From: [REDACTED]
Sent: 25 November 2024 17:04
To: Planning
Subject: Planning Application No 3/2024/0143

Proposal: Regularisation of construction of car port to front.

Address of Development: 1 Meadow Croft West Bradford BB7 4TJ

VIEW FROM FRONT OF
DRIVE

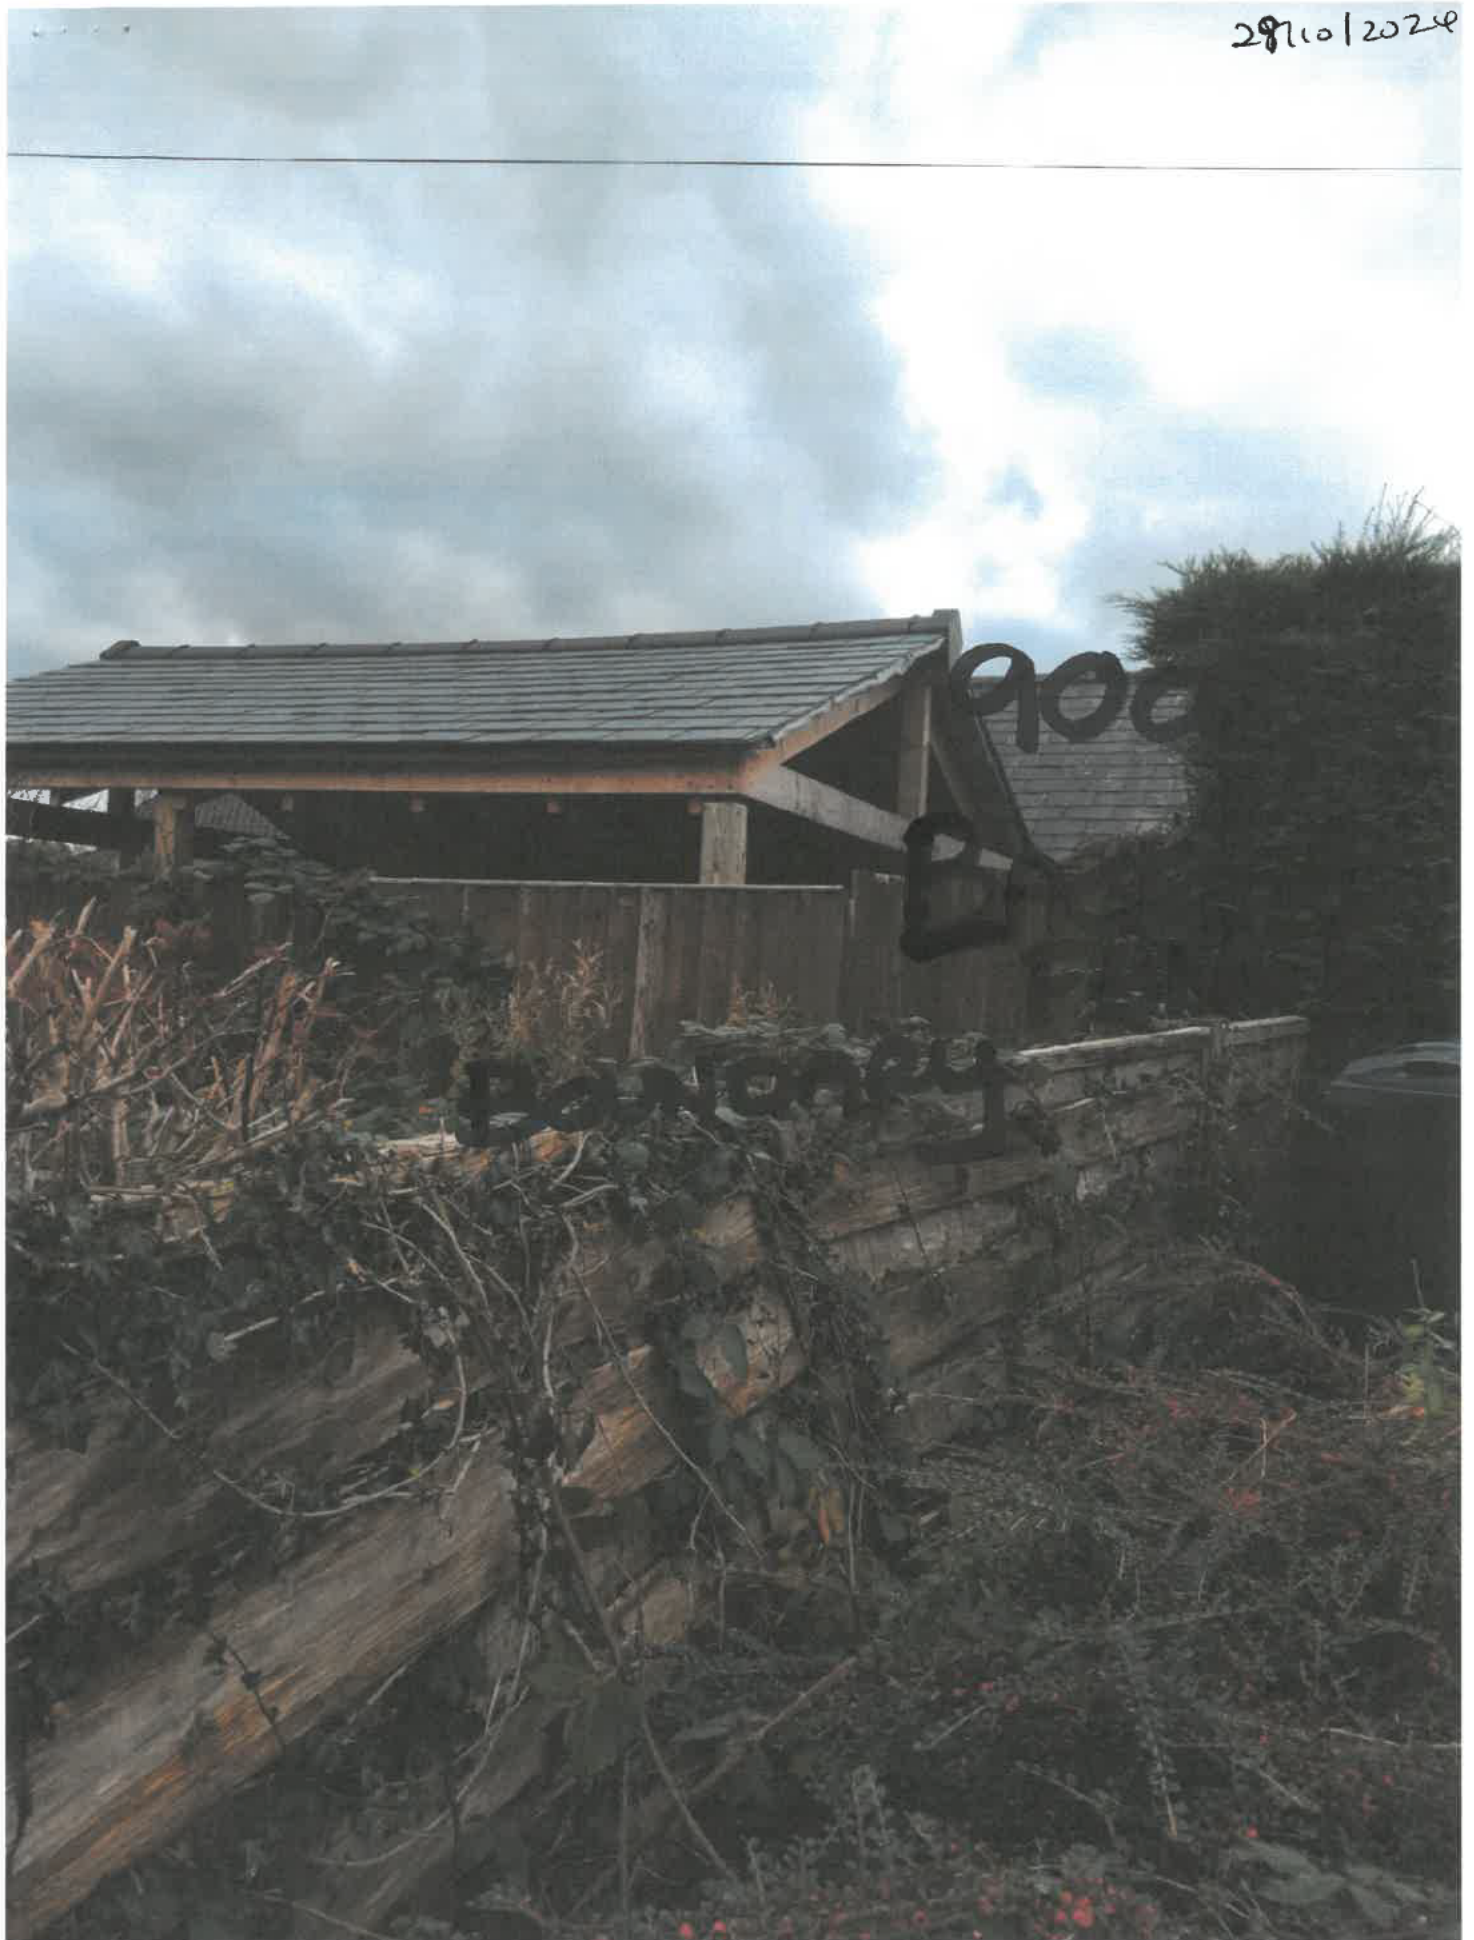
The area where the hedge should have been planted, has been concreted over and is where the car port has now been erected.

As a result, there are now three adjacent structures extending to the exterior front hedging of the property. This is both out of keeping and disproportionate to the surrounding residential properties in Meadowcroft and nearby houses in West Bradford. The ratio of buildings overshadows the green aspect of the surrounding properties and also the visual impact of the area.

We wish to object to the above proposal for the regularisation of construction of car port to front of 1 Meadow Croft West Bradford, this being a second addition. The proposal is out of character with the current garages and if approved should be rebuilt in the same stone complementing the other garages.

The hedge has never been planted therefore there has been infringement of the planning condition. The hedge would have screened the first development which in its current state is unfinished and an untidy sight to the village in particular to residents of Meadow Croft.
